APPLEGREEN PLC

DEADLINE 2 SUBMISSIONS

**M42 Junction 6
Development Consent Order Application**

APPENDIX 1 - RESPONSES TO EXAMINING AUTHORITY'S FIRST WRITTEN QUESTIONS

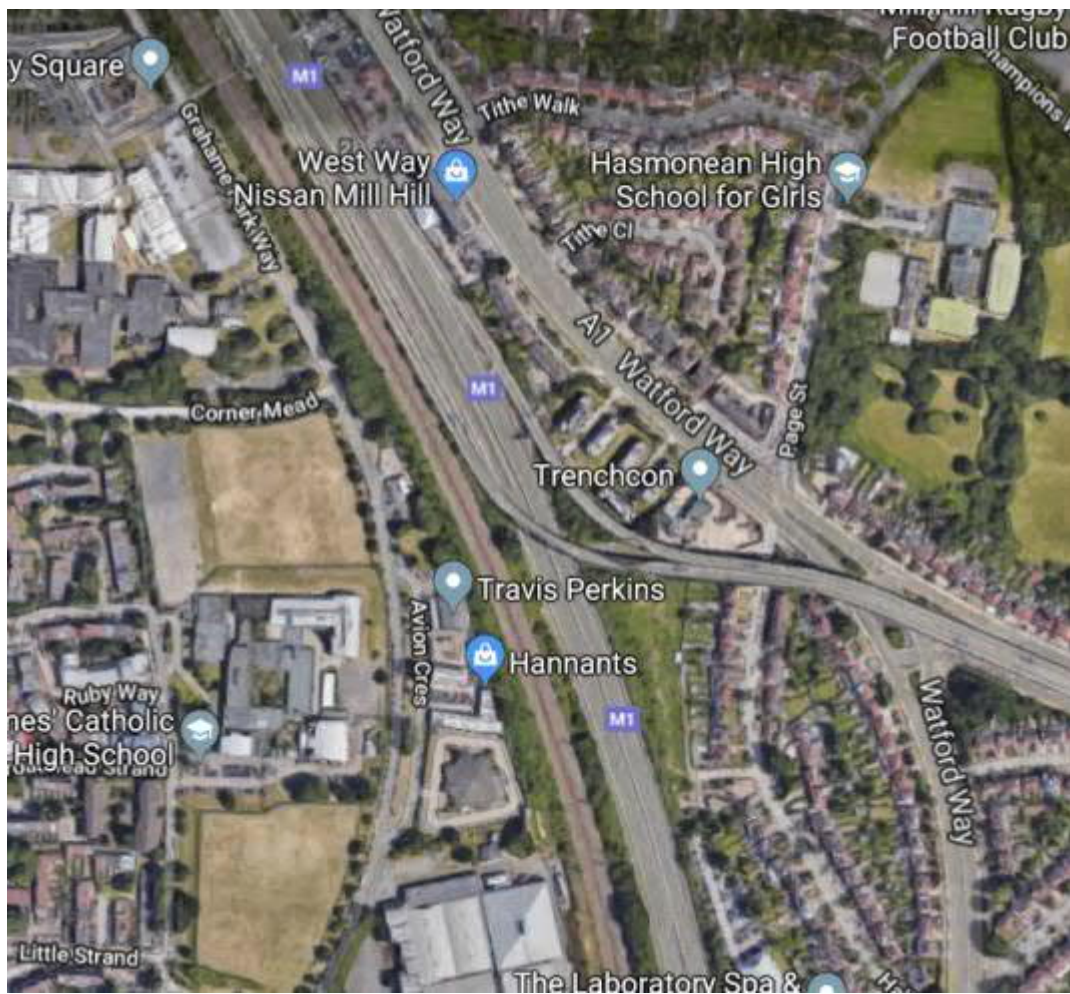
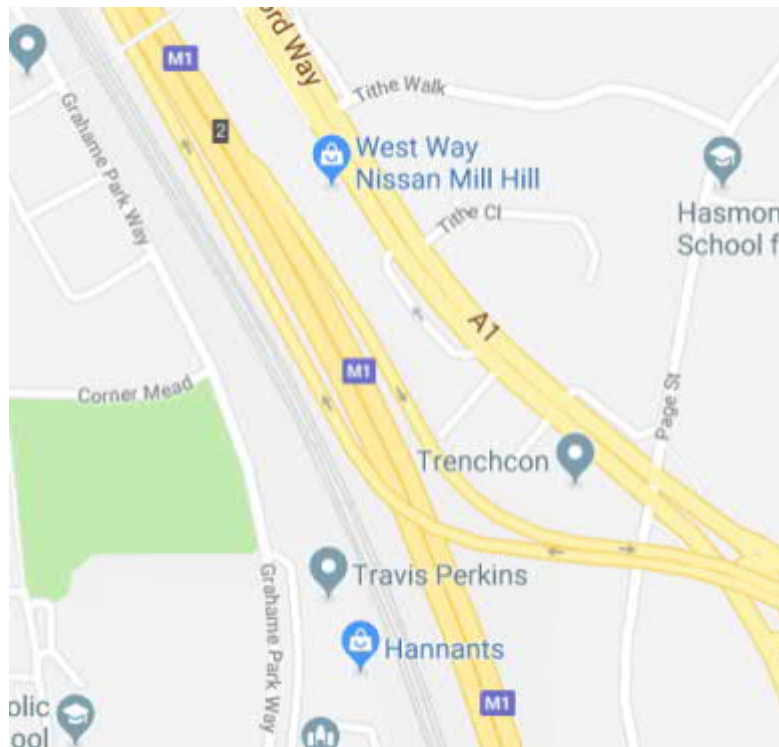
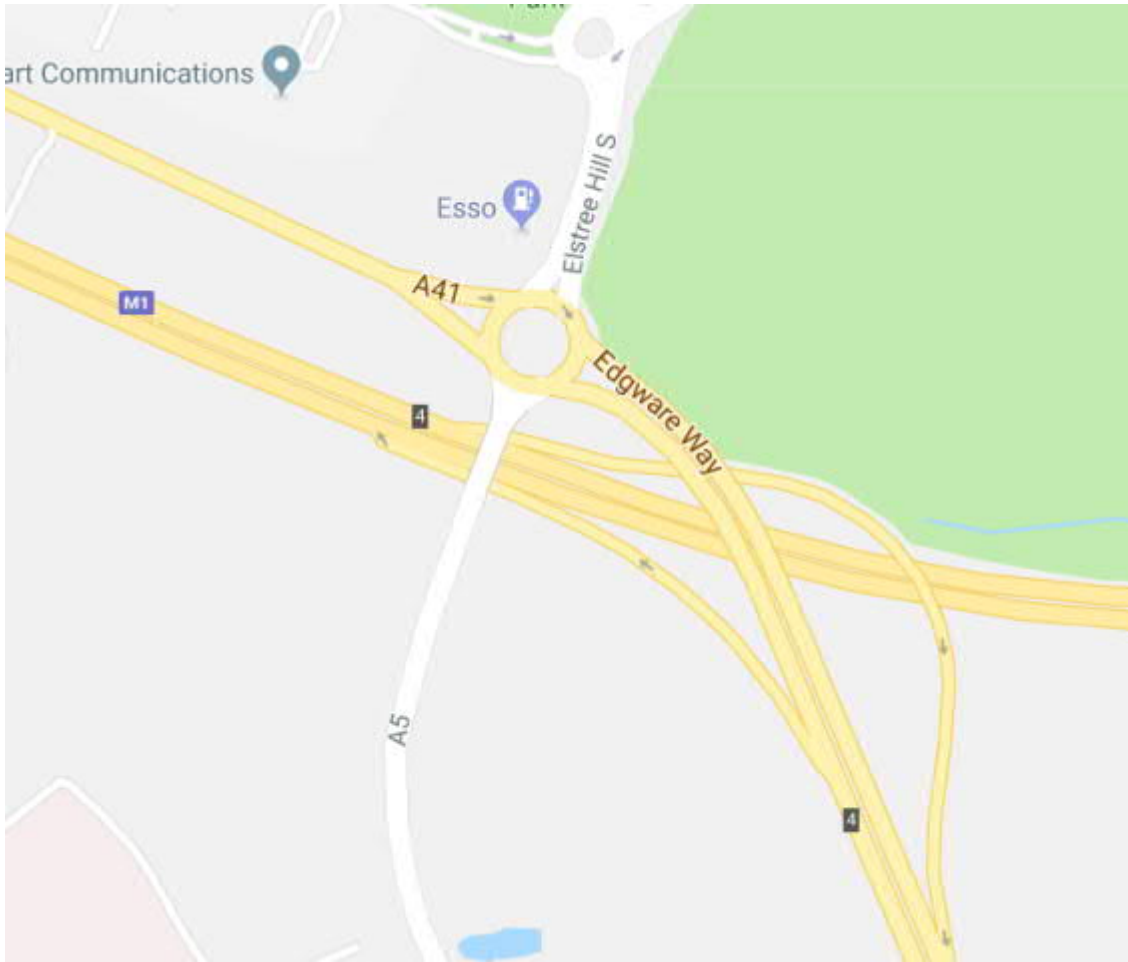
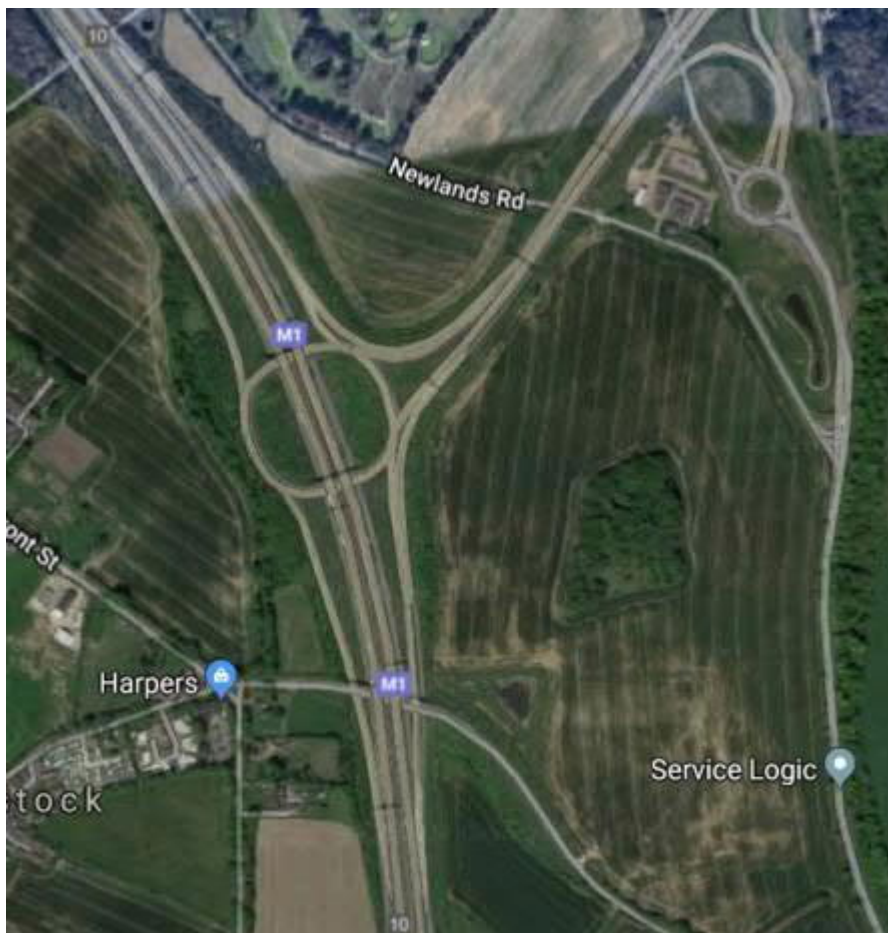
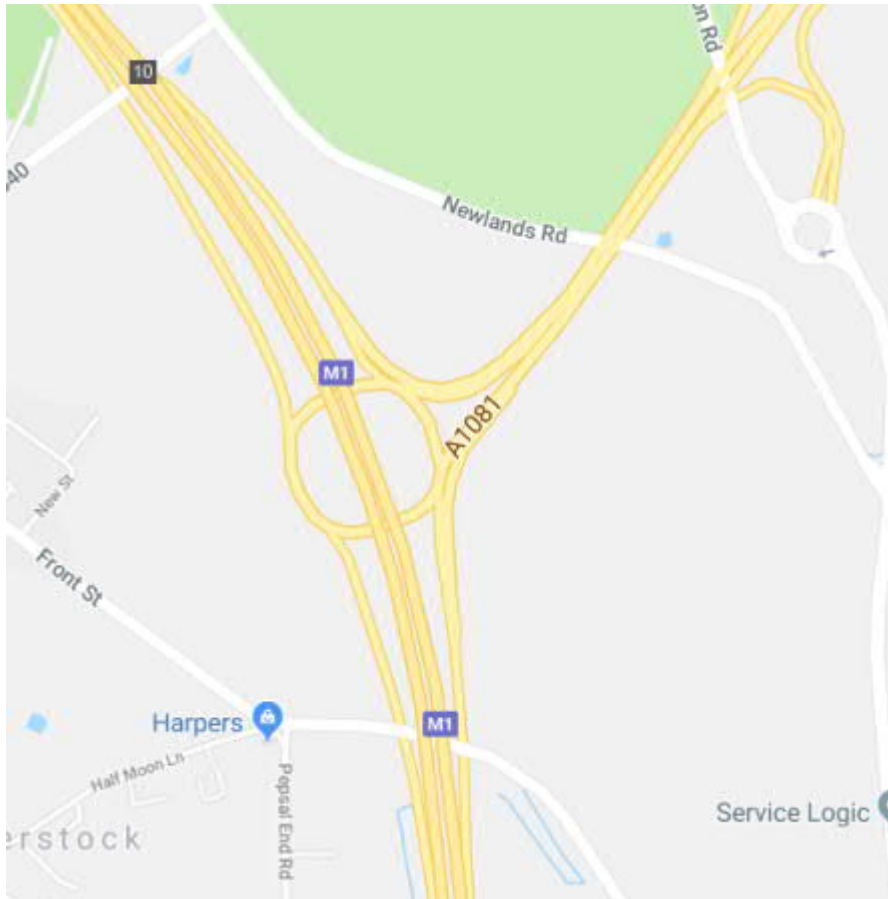
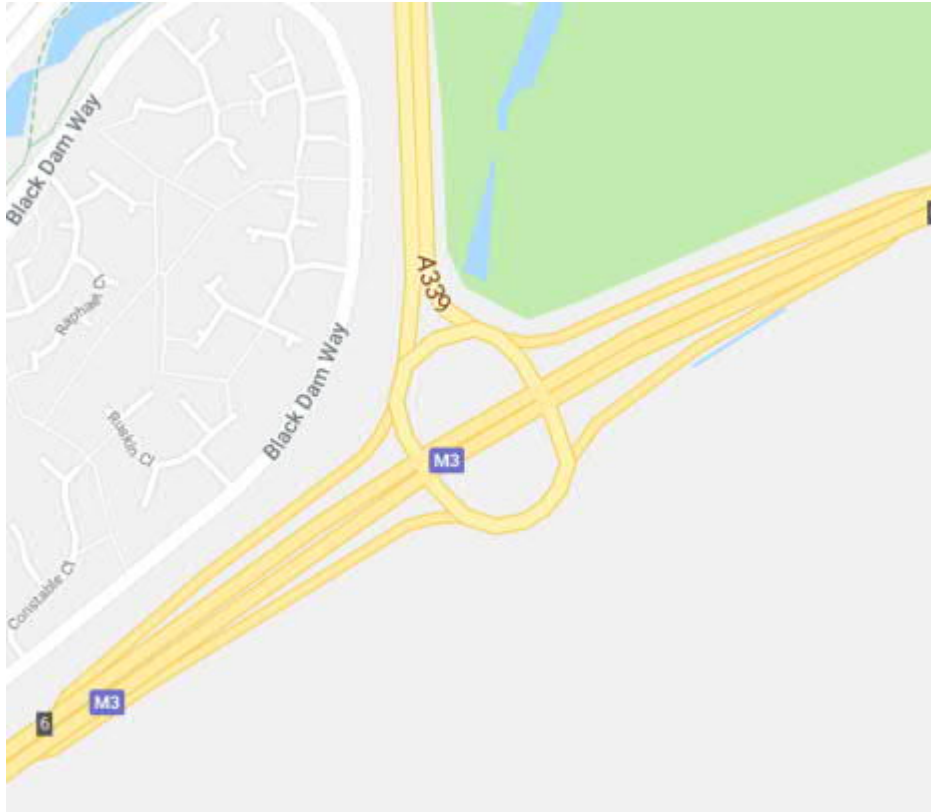
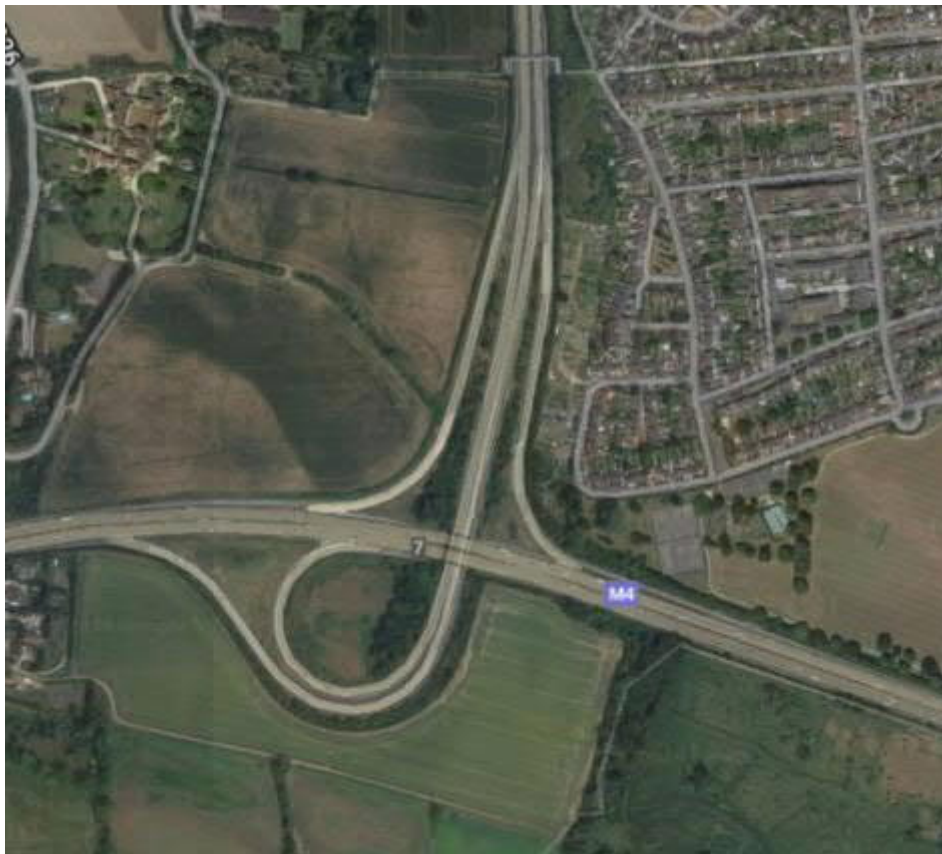
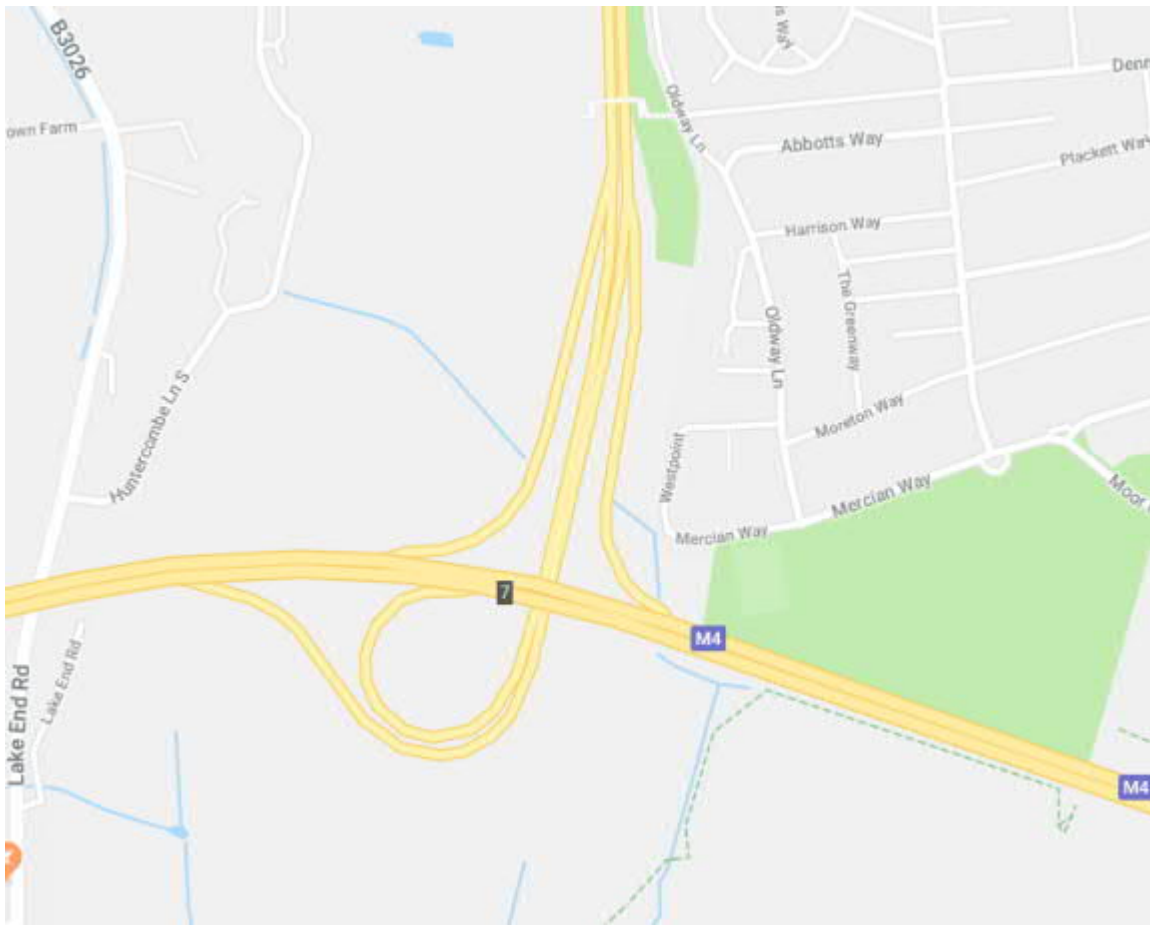
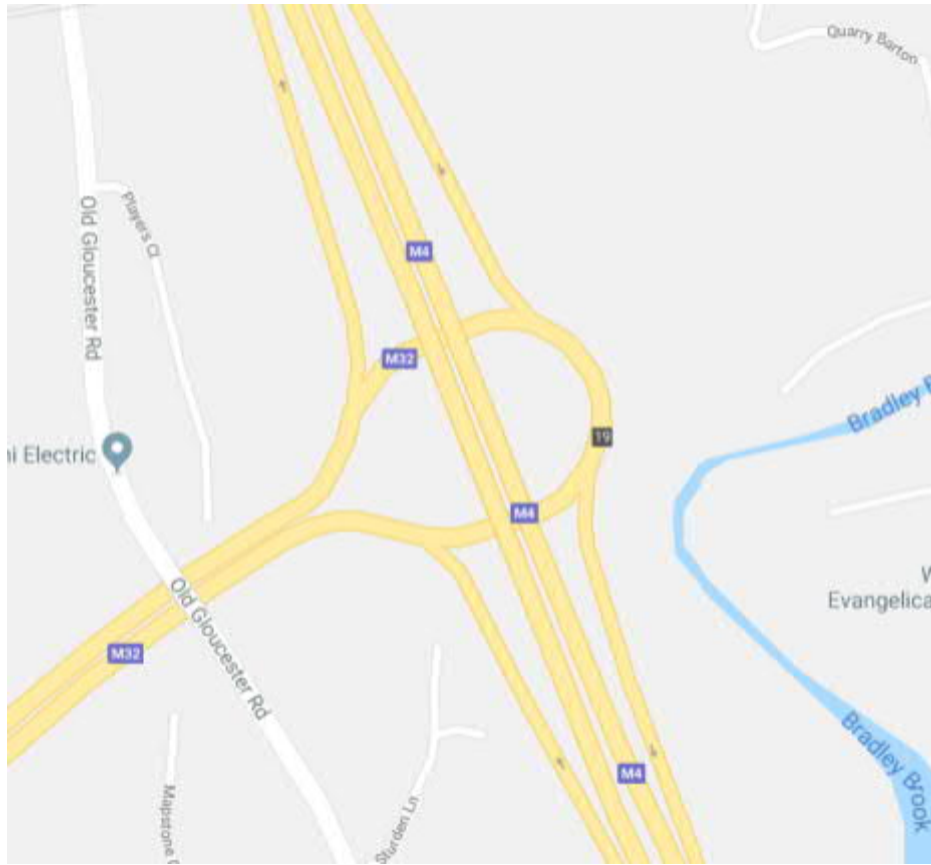
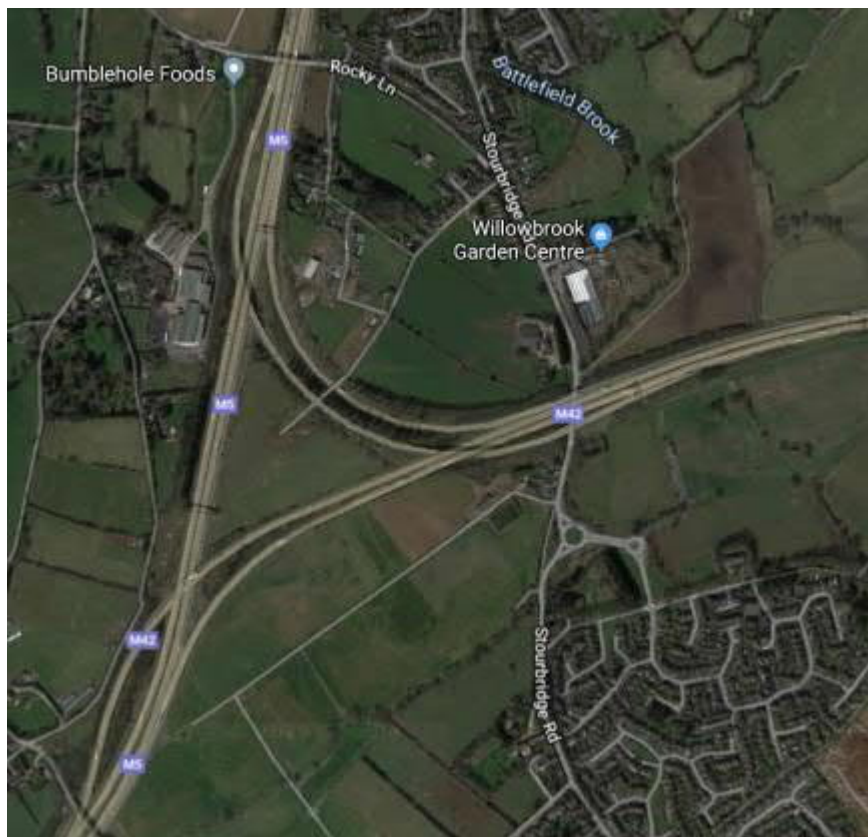
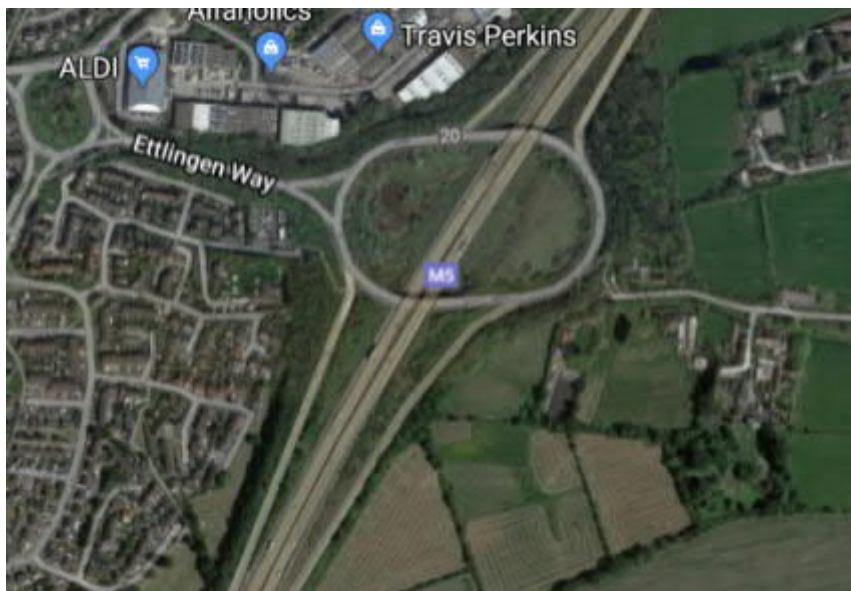
Cuthbert		<p>required to slow down at the point of give way despite there being very little if any circulating traffic. The presence of the roundabouts together with the need to give way is a less efficient arrangement as even without any conflicting traffic movements it will introduce an element of geometric delay.</p> <ul style="list-style-type: none"> • They avoid negative environmental consequences in terms of impacts upon noise and air quality associated with traffic slowing down and then accelerating away from the give way line. With a free flow arrangements traffic would be more likely to maintain a constant speed when leaving or joining the motorway. • They avoid the junction being used to facilitate ‘U’ turns on the motorway, with such movements adding an element of delay for other vehicles using the junction. • The junction motorway overbridge need only cater for traffic travelling in a single direction and therefore can be less wide. • Roundabouts, with their requisite land take and lighting requirements etc. are not required. <p>The junction design provided by Mr Cuthbert, whilst demonstrably preferable to the proposed dumb-bell arrangement, could be further optimised in that the northbound off slip road radii could be tightened to decrease the impact on the Ancient Woodland at Aspbury’s Copse. It could be materially further improved by way of moving the free flow junction further to the north. This would:</p> <ul style="list-style-type: none"> • Avoid impacts on the Ancient Woodland altogether. • Avoid or reduce the substandard weaving length between J5 and the new J5a. <p>In order to evidence the foregoing, a review has been undertaken of all the “M” roads in England including the M6 Toll Road. Motorway standard “A” roads have not been included in this review. All junctions where a single road connects to a motorway have been identified and categorised on the basis of whether they have one or two way facing slip roads and whether they take the form of a free flow junction or an interchange. In this case free flow is defined as when traffic can move between the motorway and the side road without passing through a give way or stop line. The results of this review are set out in the table below and plans of the junctions are shown in Appendix E.</p>

The review identified 42 junctions on the motorway network which connect to a single road. Of these junctions 19 had slip roads facing in one direction and 23 had slip roads facing in both directions on the motorway. **All** of the junctions which had slip roads facing one way were free flow.

In conclusion, it is clear that the junction form proposed in the DCO has been selected to accommodate north facing slip roads. This arrangement has demonstrable disbenefits and evidence from a review of the motorway network shows that this type of interchange is only used to connect a motorway to a single road when slip roads are provided in both directions.
